From: Nolan, Chris [mailto:Chris.Nolan@lancashire.gov.uk]
Sent: 16 October 2017 10:07
To: Stephen Kilmartin; planning
Cc: LHS Customer Service
Subject: D3.15.0312 SJG - Hargreaves & Coates Ltd Back St Pauls Street Clitheroe

Planning Application No: 3/2017/0920
Grid Ref: 373069 441623
Proposal: Revised application for five town-houses following outline approval 3/2015/0312 including garage block on St Pauls Terrace.
Location: Back St Pauls Street Low Moor Clitheroe BB7 2LS

#### PROPOSED FIRST FLOOR PLAN

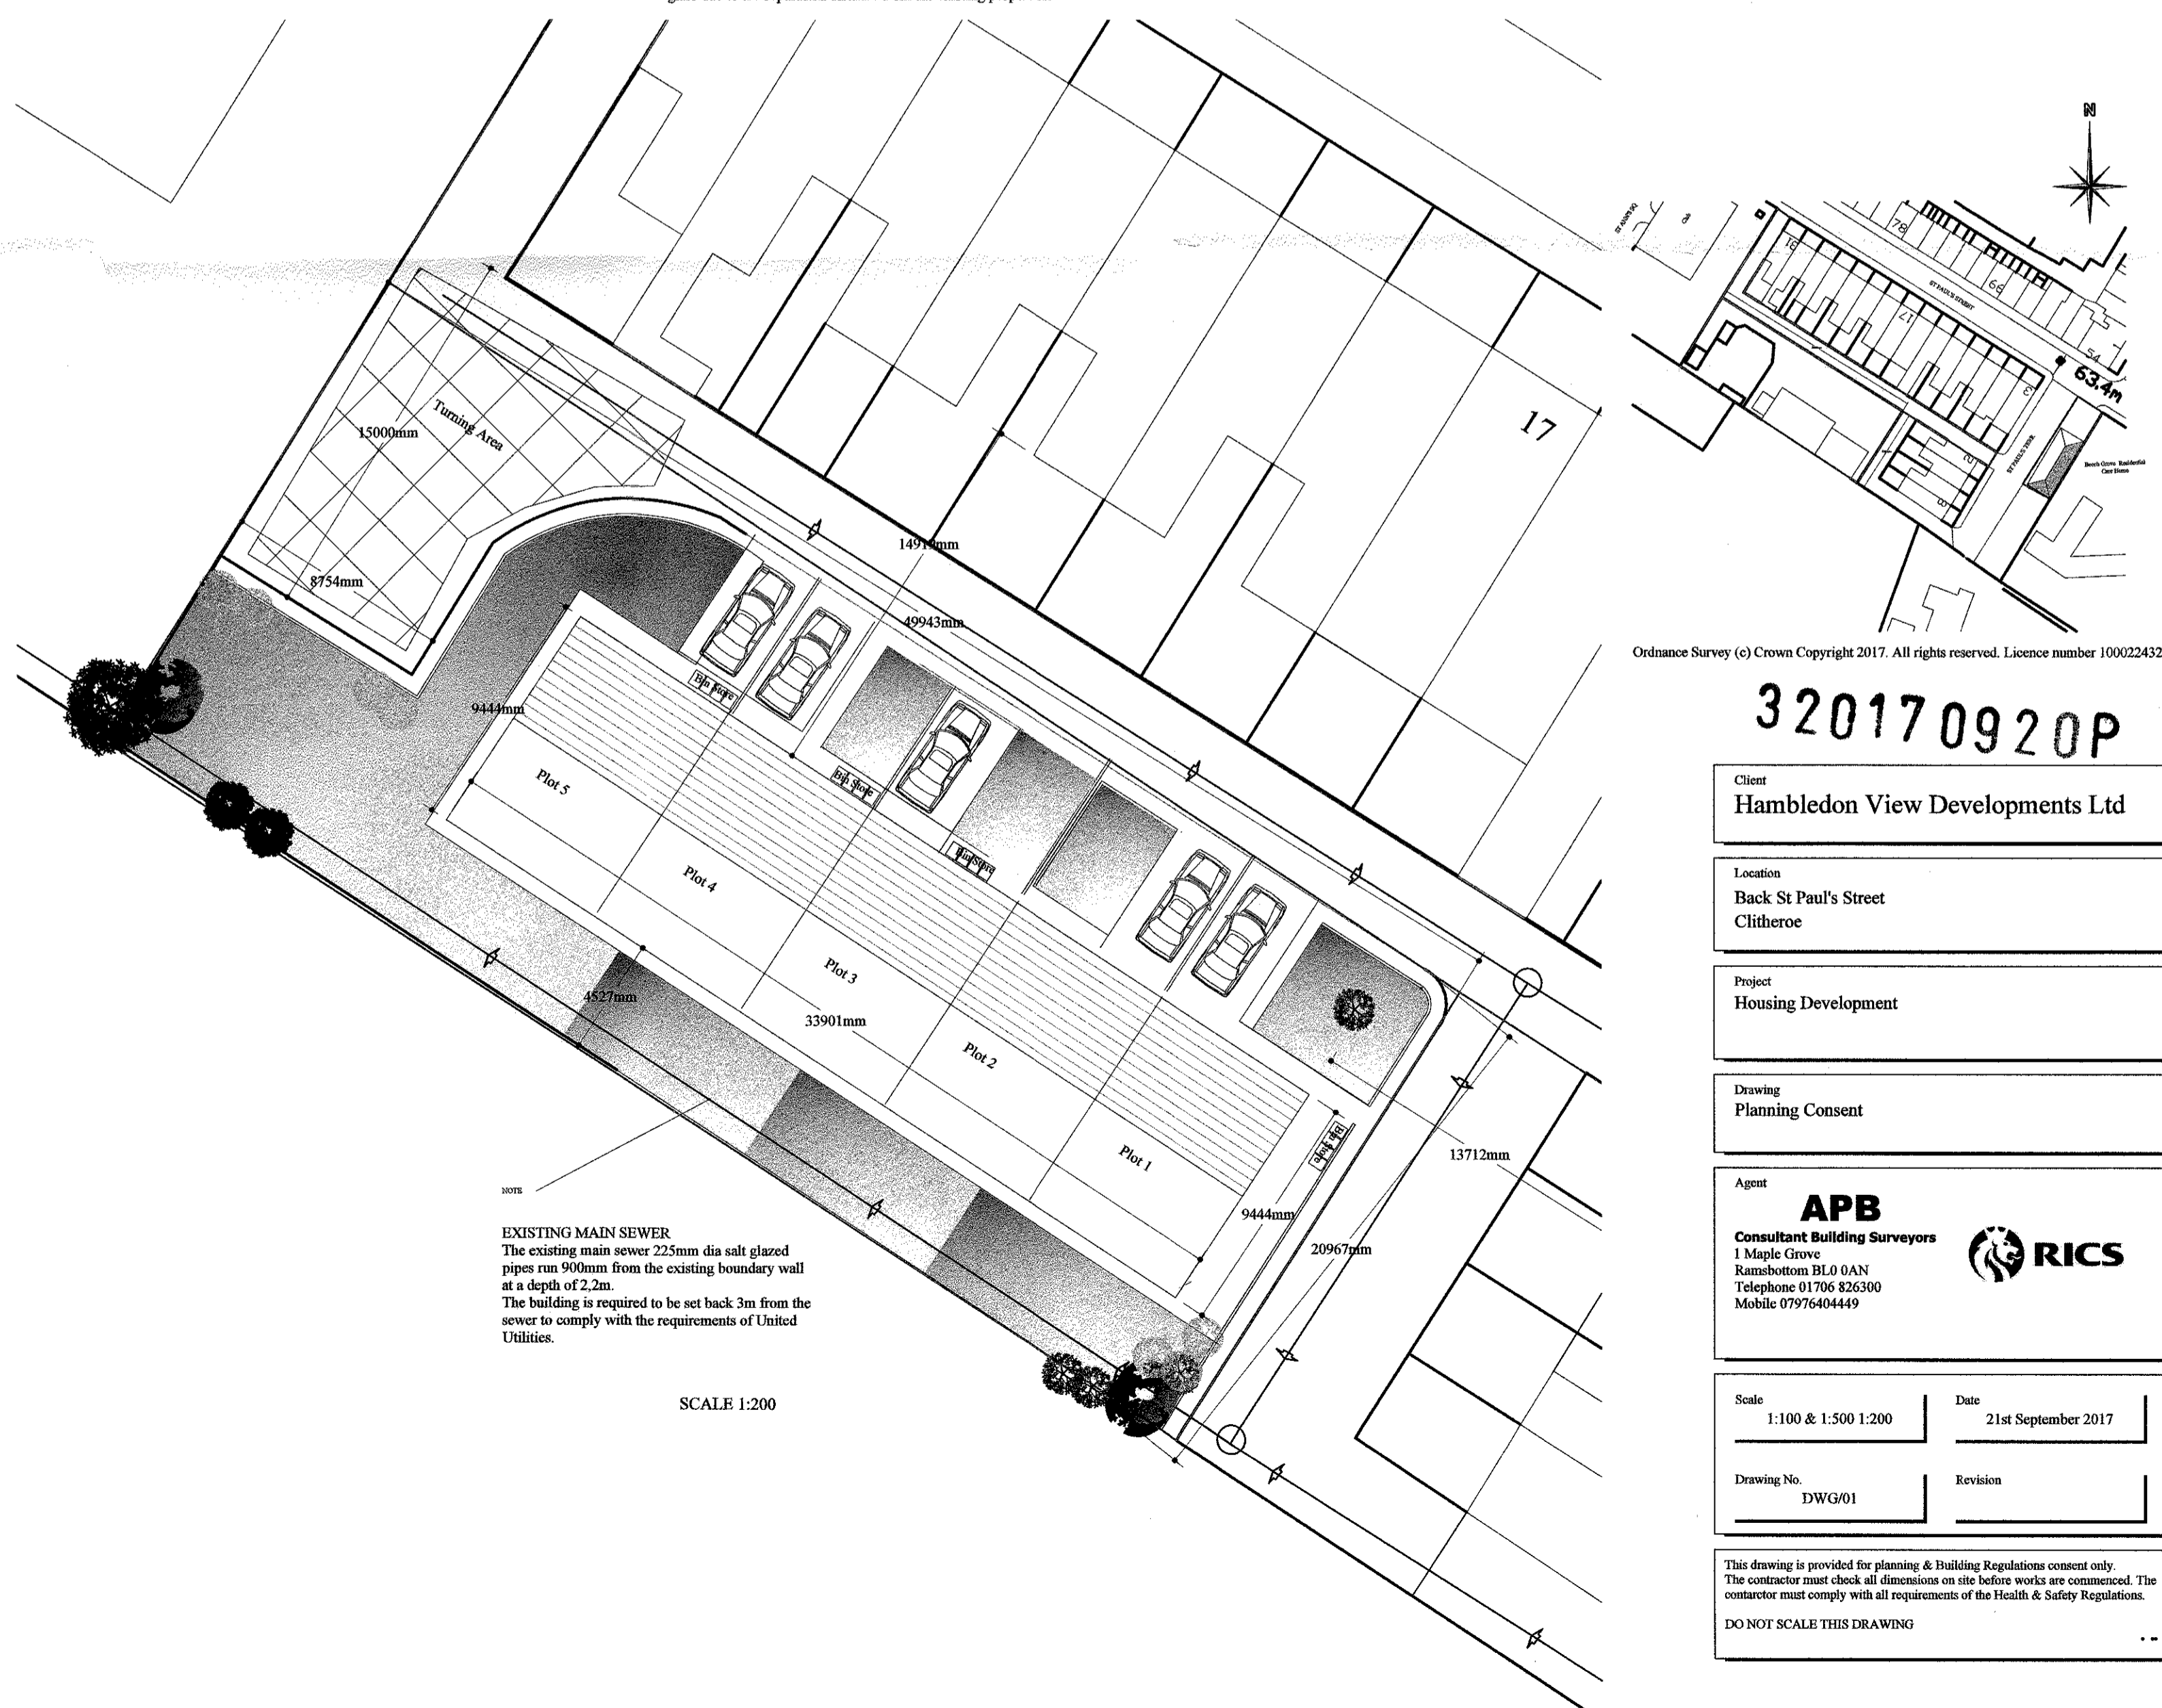
The houses that are included on the plan for this application are considerably larger and in different positions from those indicated on the final amended plan that gained outline planning permission, (3/2015/0312). The plan indicates that there will be parking bays in front of the dwellings at right angles to Back St Pauls Street. Scaling the supplied plan the bays are 5.6m long and 3.0m wide with an available width of Back St Pauls Street of 3.5m. To allow for safe reverse parking it to these bays the Back St Pauls Street would need to be 5.5m wide. I would have to say that the parking bays that are in front of the individual properties are, according to the standards (Residential Roads and Footpaths Design Bulletin 32), not accessible and therefore cannot be counted towards the parking requirements of these houses. As each 3 bedroom dwelling would have only one parking place in the form of a remote garage I would have to object to this development as it is presently set out.

Subject to an acceptable layout being provided I would not have raise objections on highway grounds subject to notes and conditions, similar to those requested at the time of the outline application, being attached to any permissions that your council is minded to grant.

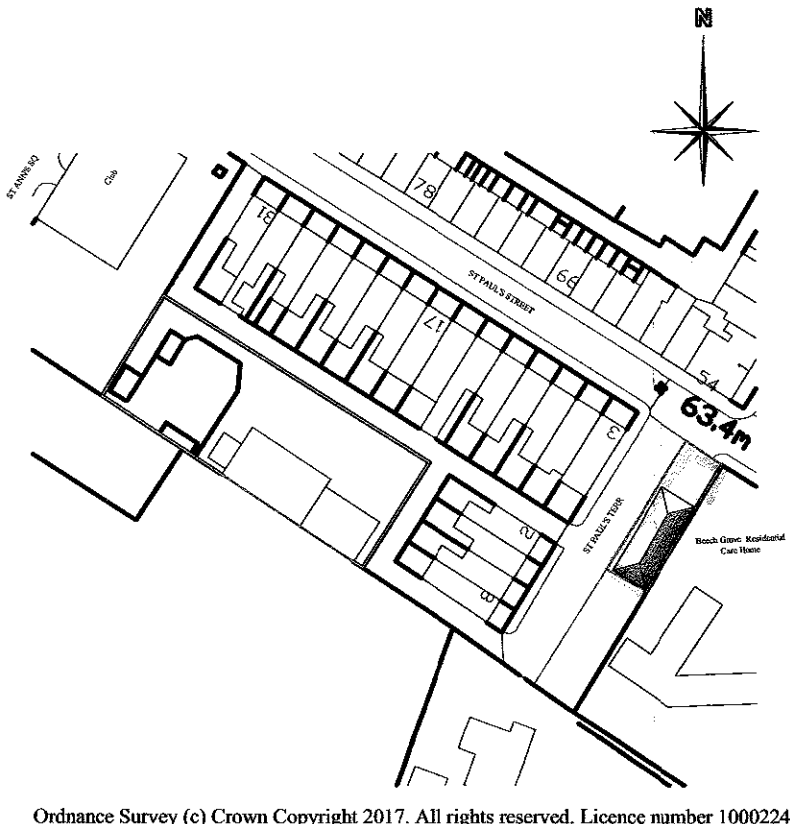
The proposed garages will be of sufficient size to meet modern standards in that there is enough internal space to accommodate both a family car and some cycles and therefore would assist the sustainability of the development. The position of the garages indicates that there is 8m between the doors and kerbline of St Pauls place and so will allow the garages to be functional even when cars are parked adjacent to No 3 Saint Pauls Street. Considering these design factors I would not have highway issues with the garages as long as they were built with roller shutter or similar doors that remain within the confines of the garage.
